Our Ref: FG/180/14/L
Your Ref:

Planning (Listed Buildings and Conservation Areas) Act 1990 (as amended)
Planning (Listed Buildings and Conservation Areas) Regulations 1990 (as amended)
Application for Listed Building Consent for Alterations, Extension or Demolition of a Listed Building

Development Application for Listed Building Consent to remove existing sash windows & replace with new to match existing
Location Bramble Cottage 50 Sea Lane Ferring

SITE AND LOCATION PLAN

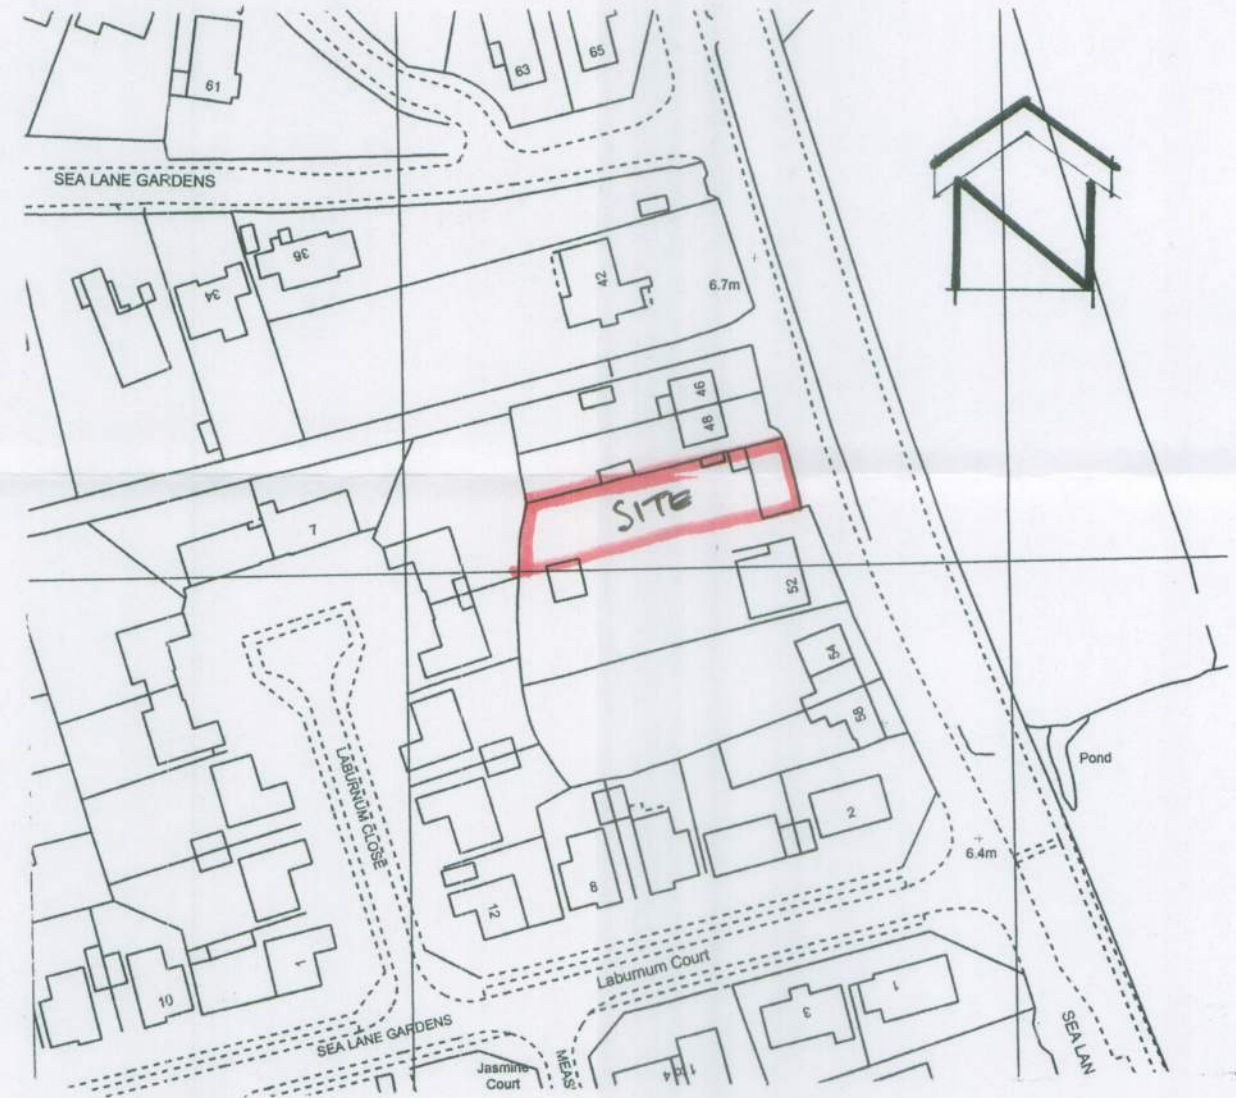
Block Plan

Please submit 1 electronic or 3 paper copies of a revised block/site plan at a scale of 1:500 or 1:200, please indicate which elevation is being affected by the replacement windows. Further details of what must be included on the plan can be found in the National Validation Requirements.
